From: Simon Davis
Sent: 21 January 2019 12:54
To: 'ed' <[REDACTED]>
Cc: [REDACTED]
Subject: RE: BN/55/18/PL

I am enquiring about the regularisation application for a stables building at Orchard End, Highground Lane, Barnham, PO22 0BU with application number BN/55/18/PL.

North-West Elevation

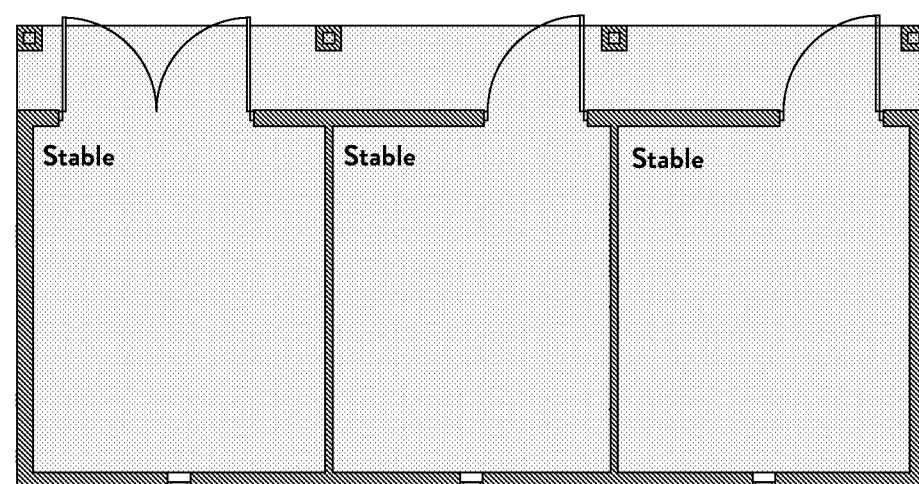
I have attached below a picture which shows the dotted line of what was permitted and the actual build size which was 400mm longer than the permitted 11.6 metre building which was an honest mistake.

I don't consider there to be a material difference between the approved and proposed and therefore, it will be my intention to recommend approval when I come to write the application up. Therefore, I have no objection to you carrying on the build. I have also informed Rose Dannatt, Enforcement Officer, of the advice that I am giving to you.
